HINCKLEY NATIONAL RAIL FREIGHT INTERCHANGE

Blaby District Council (IP ref. 20040018) joint response with Hinckley and Bosworth Borough Council (IP ref. 20039546) on design matters of HNRFI DCO Examination (ref. TR05007).

Deadline 3 - November 14, 2023

Landscape Design

Fig 6. Parameters Plan and Key

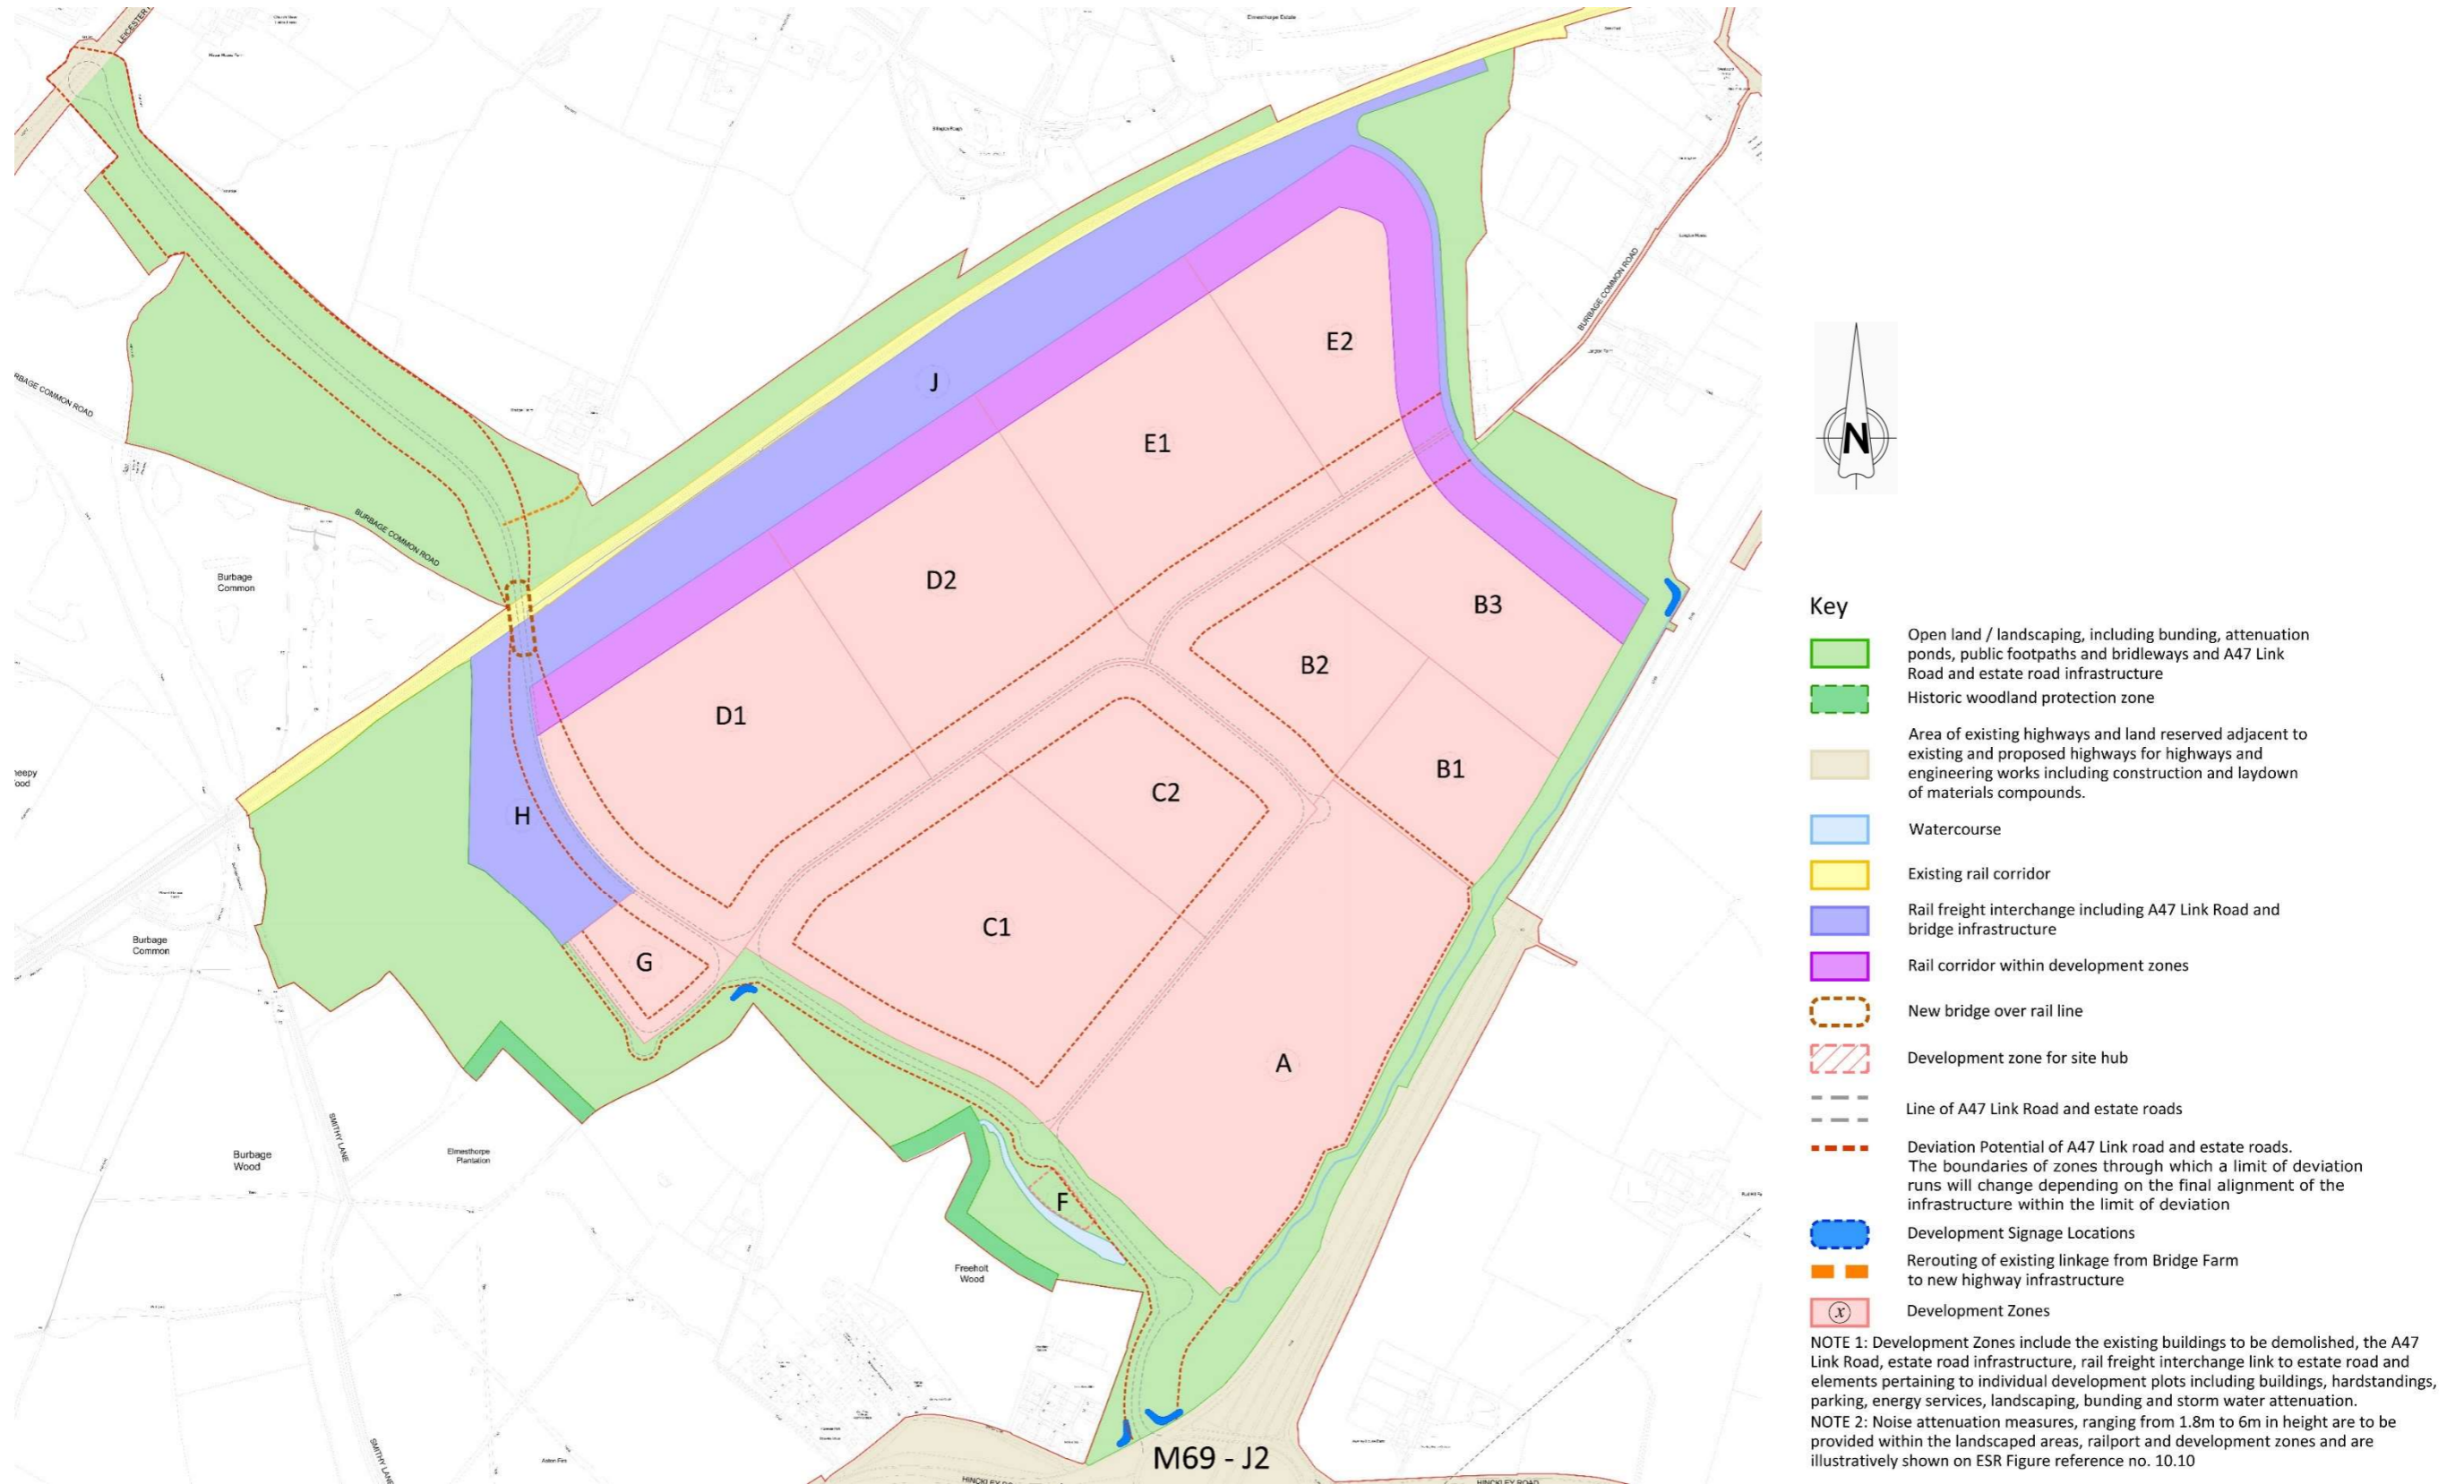
30 Page 12, section 3.1	31 Scheme parameters	The parameters plan was informed by, and evolved as responses, feedback and constraints were fed into the design.	32 The majority of the comments outlined in the LUC design report regarding character, scale, impact on nature and the locality were raised independently by other parties during consultation. The scheme doesn't appear to have taken these comments into consideration.
33 Page 14, section 4.1	34 Rural aesthetic	Within the main HNRFI site, in order to deliver a successful SRFI, it is not possible to maintain or recreate the existing rural aesthetic, as the development requires large regular building plateaus	35 We disagree that the landscape design cannot reflect the existing rural aesthetic at least in part. Sensitive design of planting and material selection

Fig. 2935 – Typical Elevation Material Application

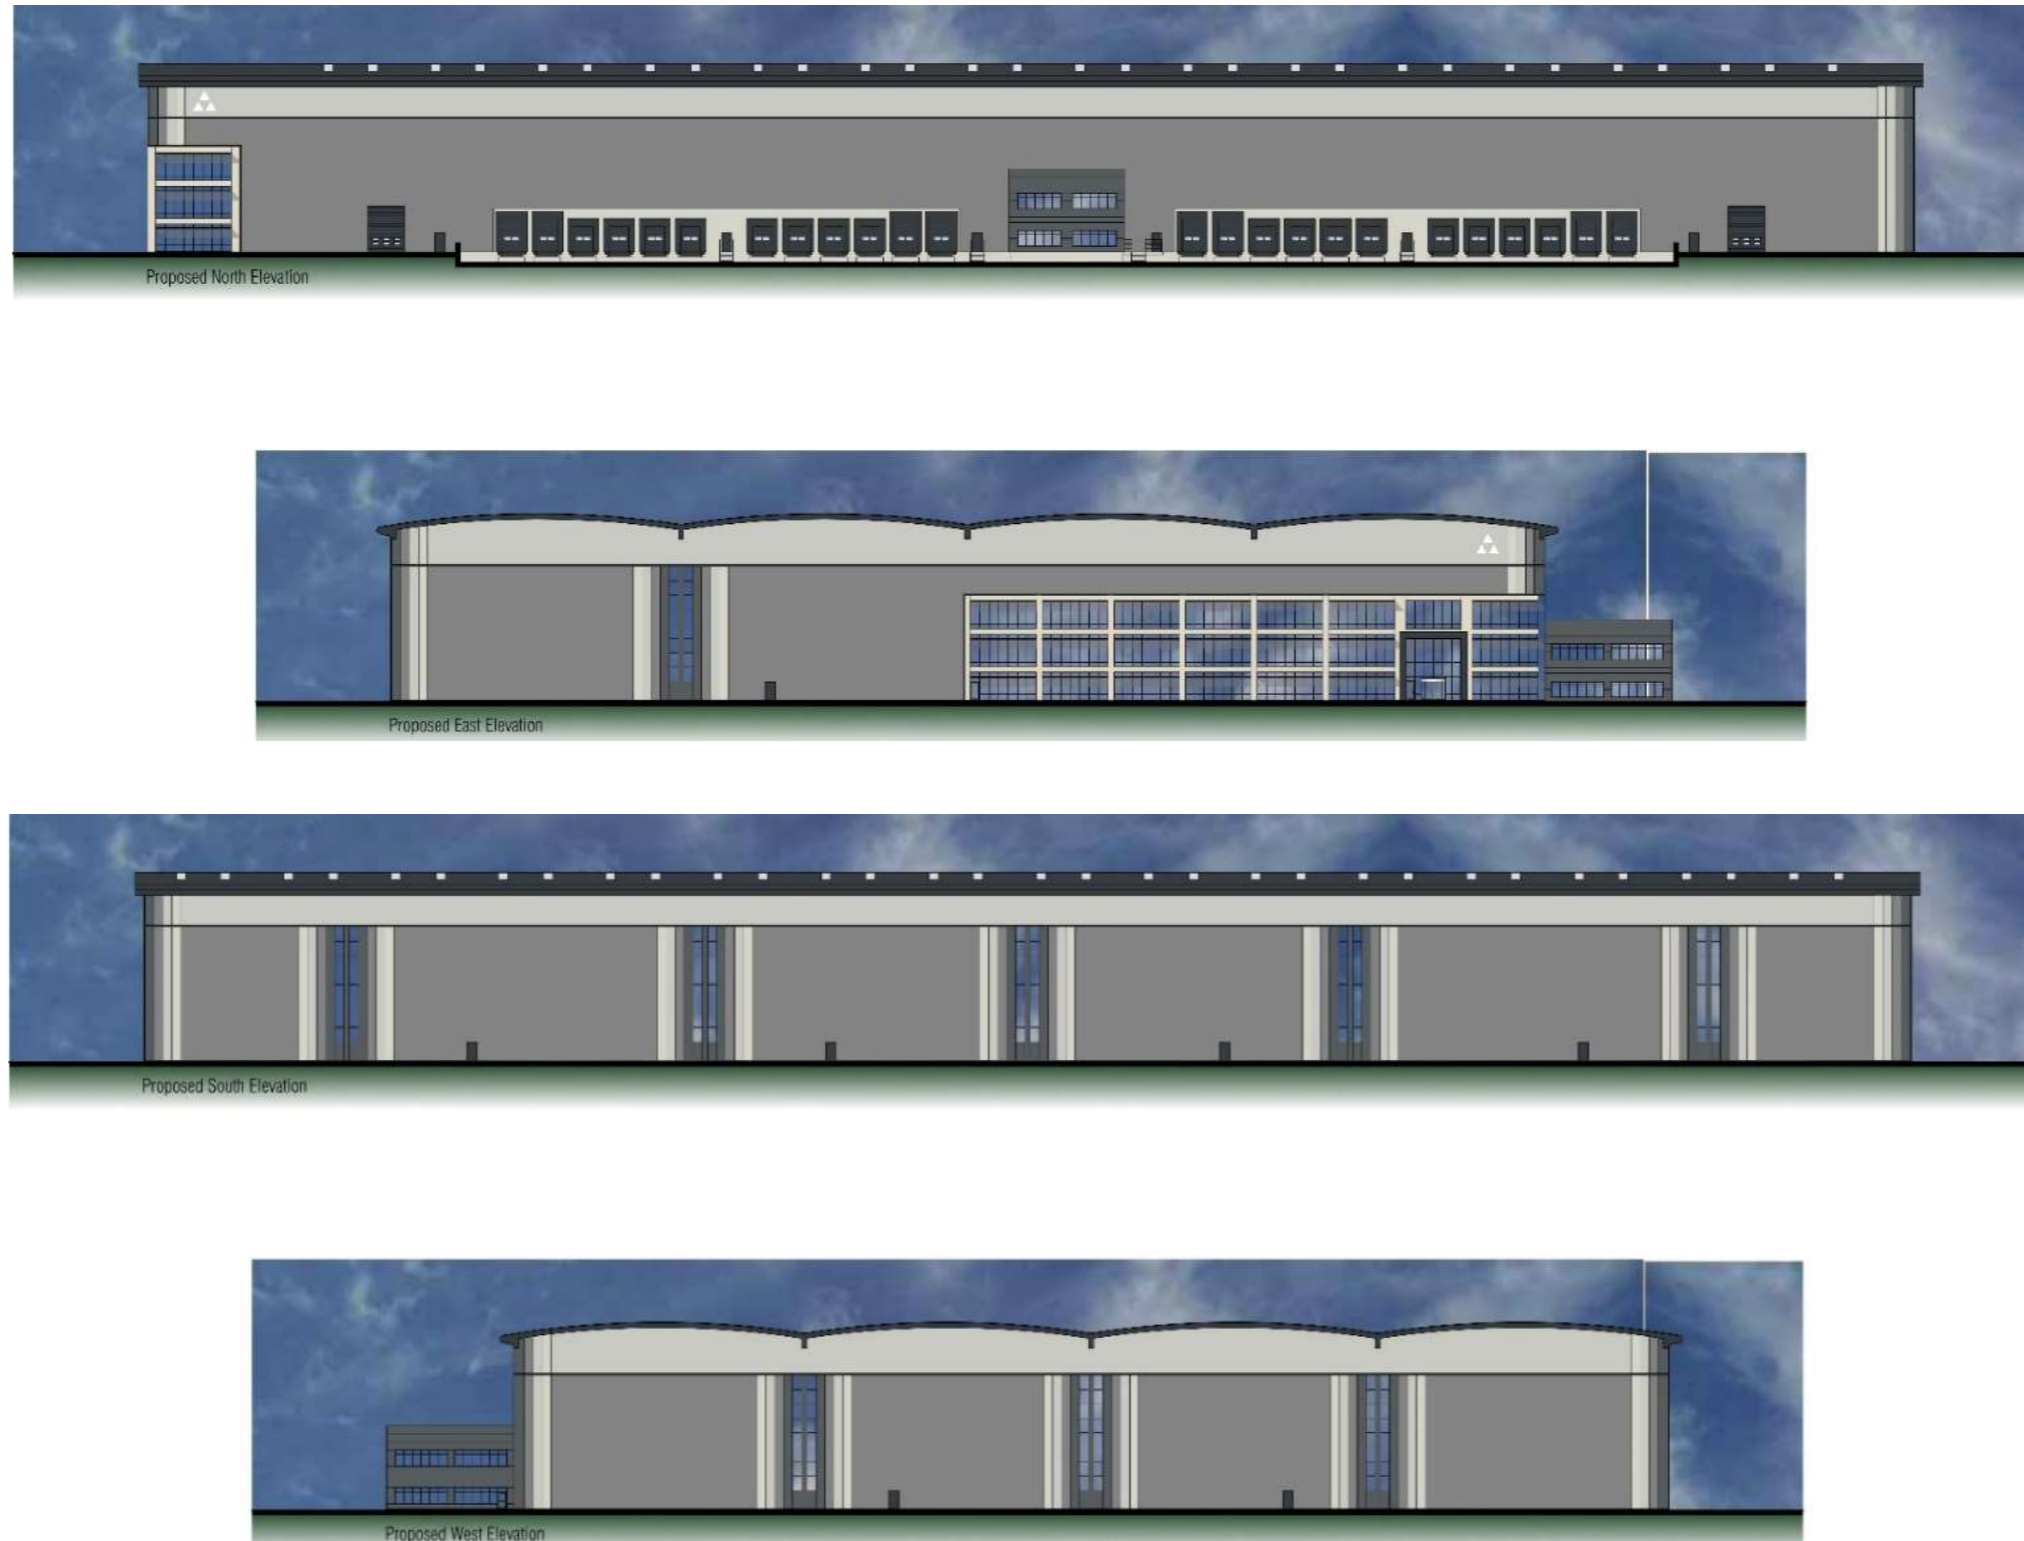
On the point of architectural form the applicant described the roofline as 'curvaceous and organic'. Following review of the proposed elevations it would be reasonable to come to the conclusion that this statement is an exaggeration of what is in reality is a repeating curved roofline. This form introduces a foreign monotony into the landscape and due to its scale appears to worsen the visual impact of the scheme compared to a more reasoned, sensitive approach where efforts could have been made to break up this massing.
